Company:	Cimarron Hills Fire Dept.	Date:	11/19/2025
Address:	1835 Tuskegee Place Colorado Springs, CO 80915	Project:	Chick-Fil-A SPD
Attention:	Thomas P. Joyce Division Chief of Fire and Life Safety	From:	Kyle Goodwin, P.E.
Re:	Permit/Approval Explanation	File No.:	PPR2251

Comment and Response Letter:

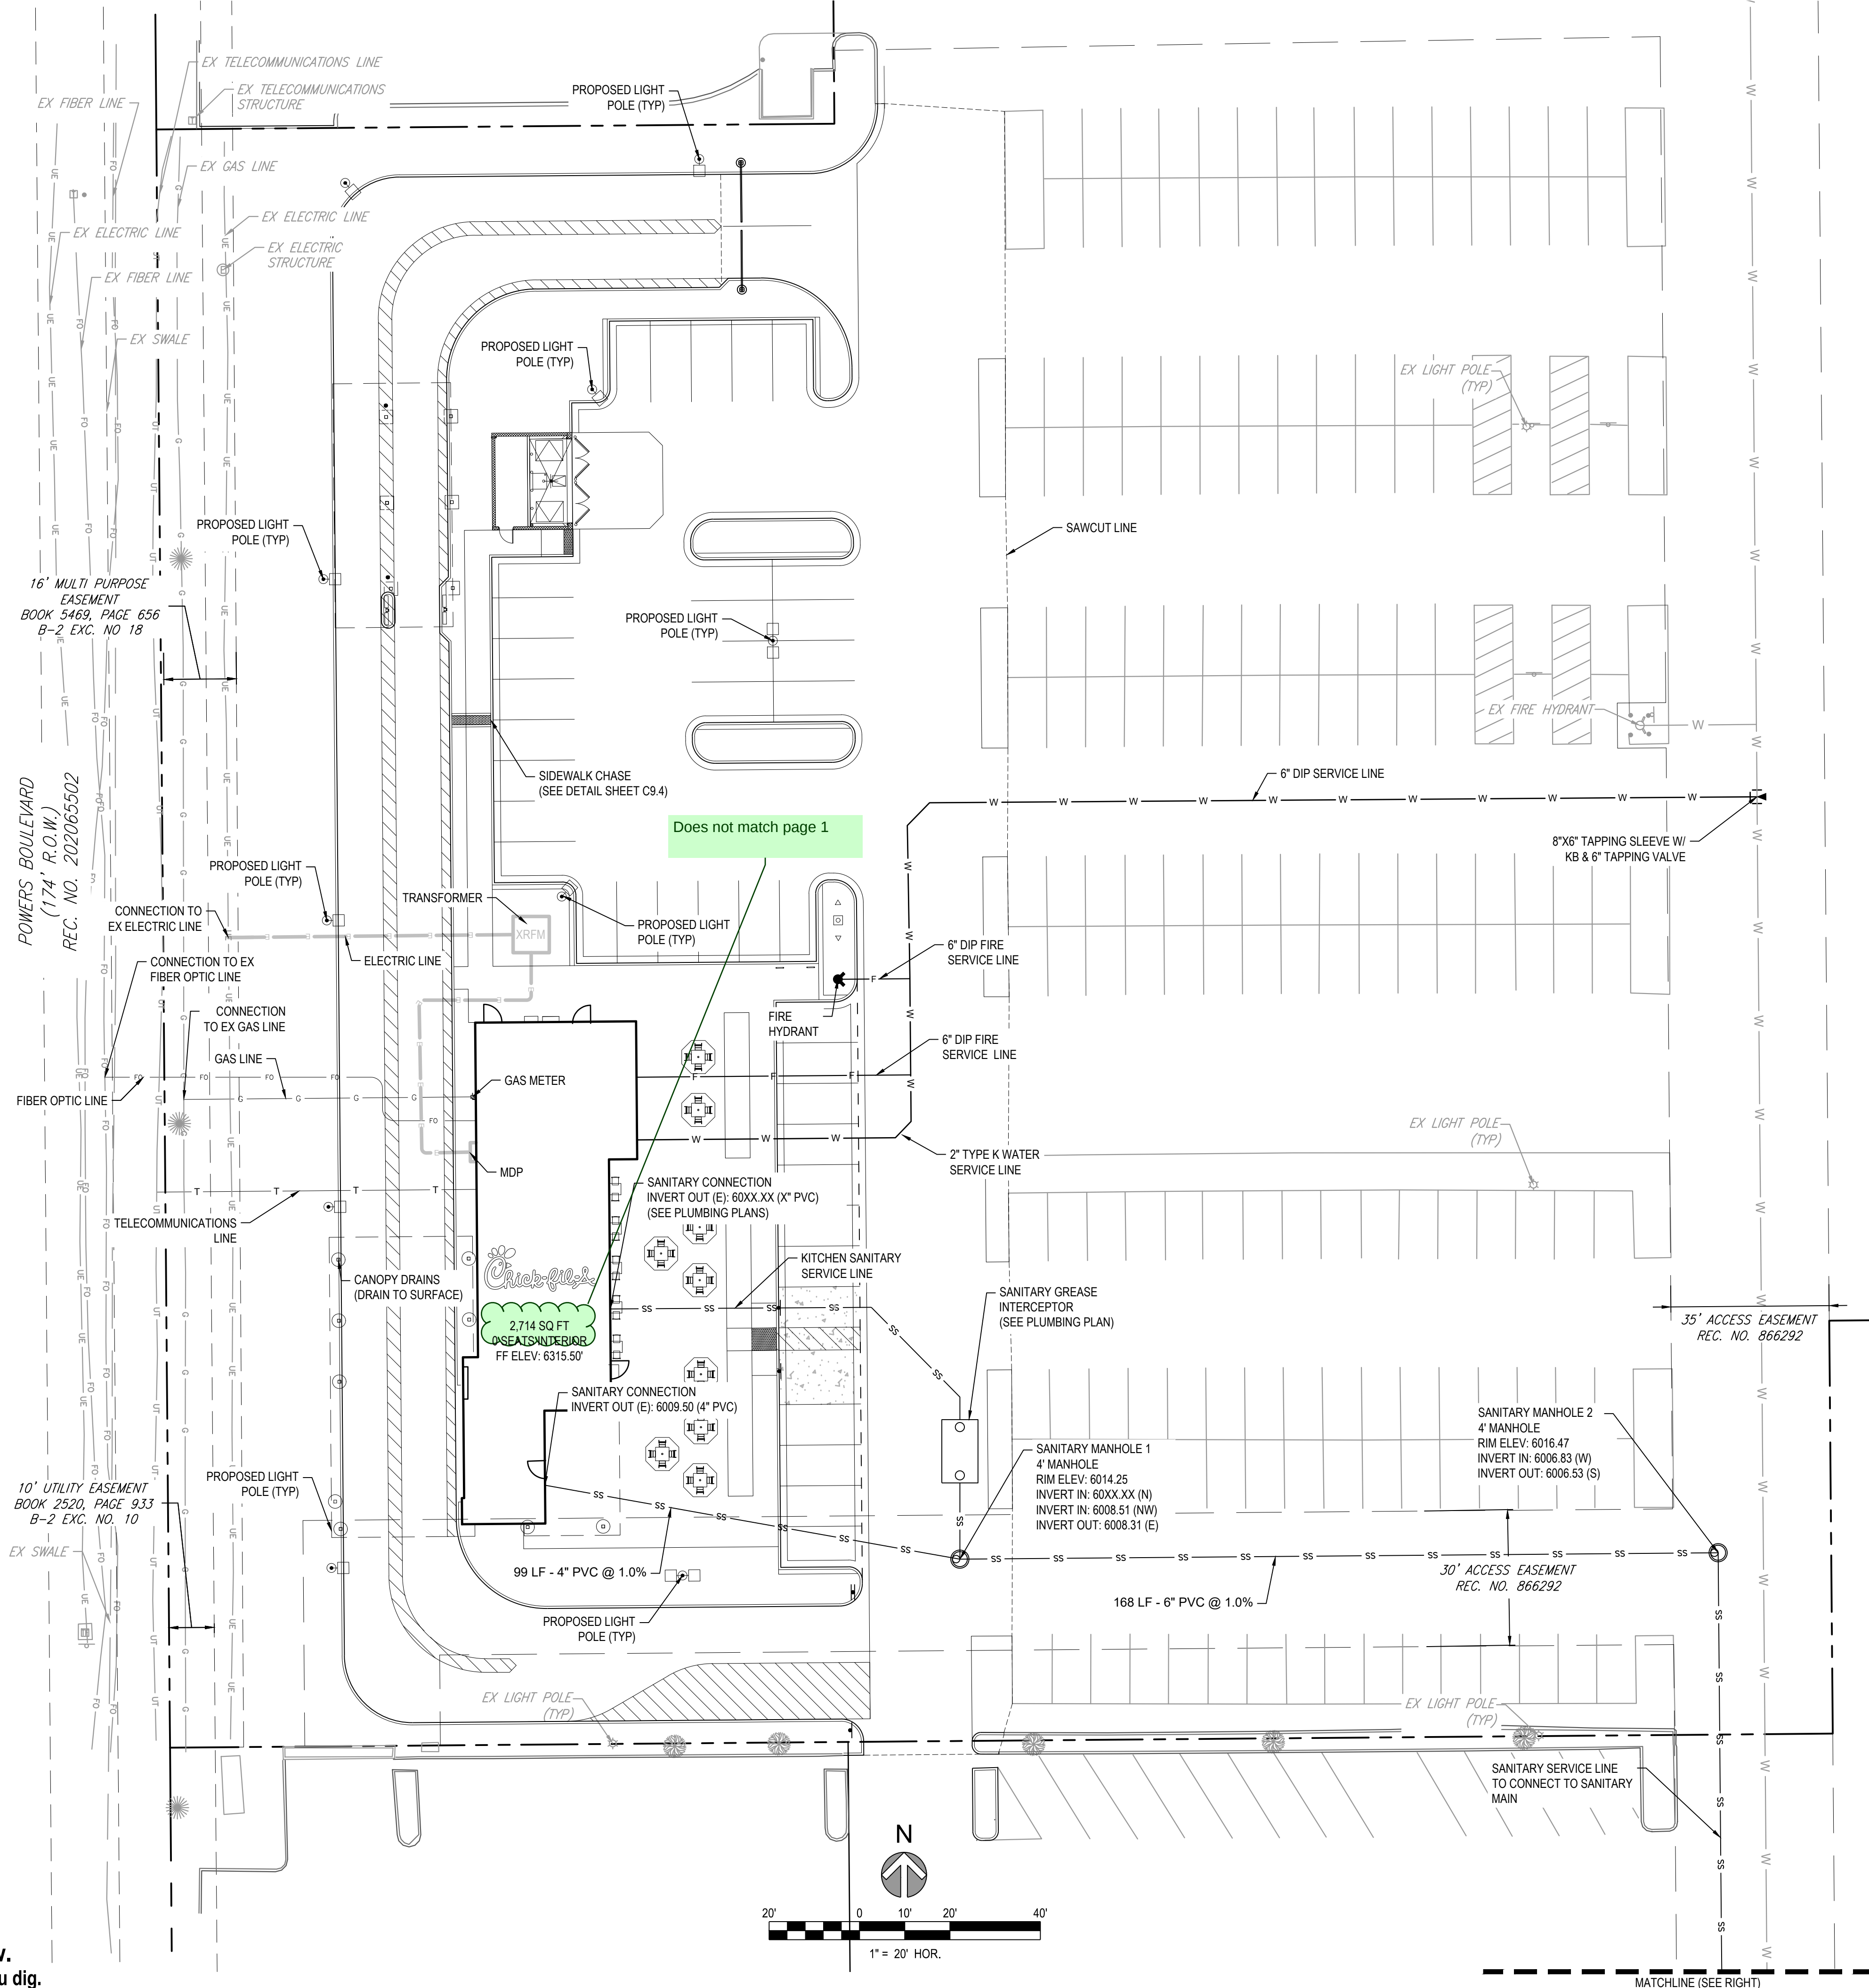
1. Comment: Limited fire apparatus turning and staging space, which poses challenges during emergency response.

2. Comment: Tight stall dimensions limit vehicle maneuverability for both private vehicles and emergency responders.

3. Comment: Insufficient aisle widths that do meet standard fire lanes or fire department access road width requirements as outlined in the applicable editions of the International Fire Code (IFC) and El Paso County Developments Standards.

Response: A survey of the existing parking lot in front of VASA was completed by Merrick & Company. A Vehicle Tracking analysis was performed for a firetruck access route coming in off Palmer Park Blvd, turning into the parking lot, serving the Chick-Fil-A building, maneuvering through the parking lot, and leaving via the same access point. Along this route, the minimum drive aisle width is 28' and the firetruck can make turns around the existing and proposed islands without striking them.

Response: The truck turn has been provided to demonstrate the feasibility of access to the proposed development.

Response: Per the 2015 IFC code, the minimum fire lane width is 20' which is met throughout the existing and proposed portions of the parking where the minimum drive aisle width is 24' in the parking lot, but 28' throughout the firetruck access route.
